From: Sue Howell <Sue.Howell@arun.gov.uk>
Sent: 16 June 2021 16:16
To: Planning.Responses <Planning.Responses@arun.gov.uk>
Cc: Andrew Wood <Andrew.Wood@arun.gov.uk>
Subject: Planning Consultation on: LU/151/21/PL

Response to Planning Application

From: Arun District Council Greenspace

Location: 25 River Road Littlehampton BN17 5BZ

drawing Proposed Site Plan

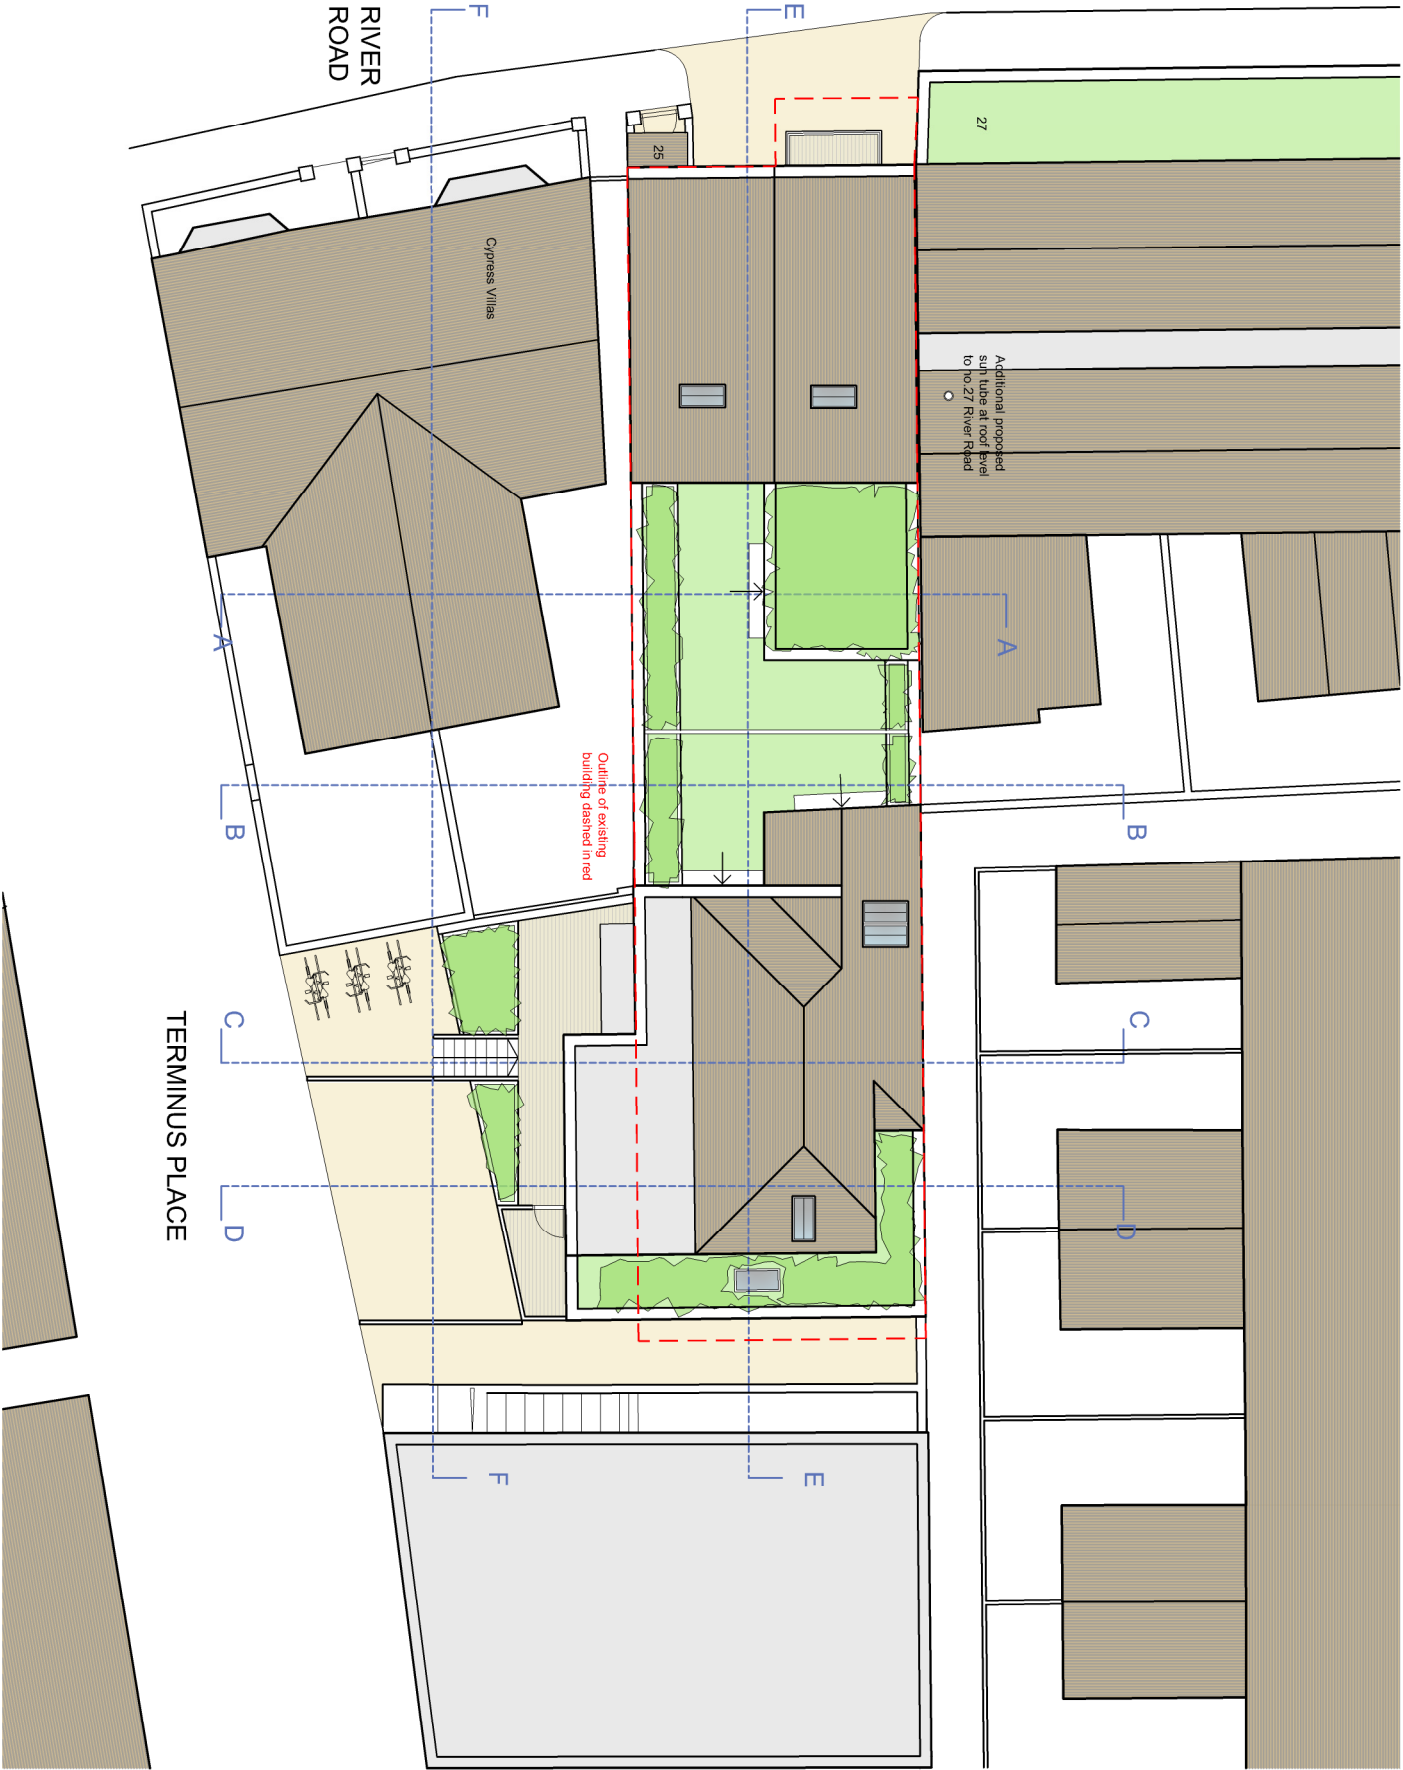
Further onsite landscape mitigation would be required, presently shown as indicative. This detail would need to be expanded into plan form detailing planting species, quantities, planting densities and size at time of planting. All landscape mitigation would need to be appropriate for location and provide suitable screen mitigation as required.

These details are required to ensure that appropriate screening is provided, maintaining and uncompromising the setting and ensuring that the proposals are fitting, providing screening as required, increasing biodiversity and wildlife habitat.

Recommend **no landscape objection** to the proposals, subject to submission of full landscape scheme details to be submitted and approved.
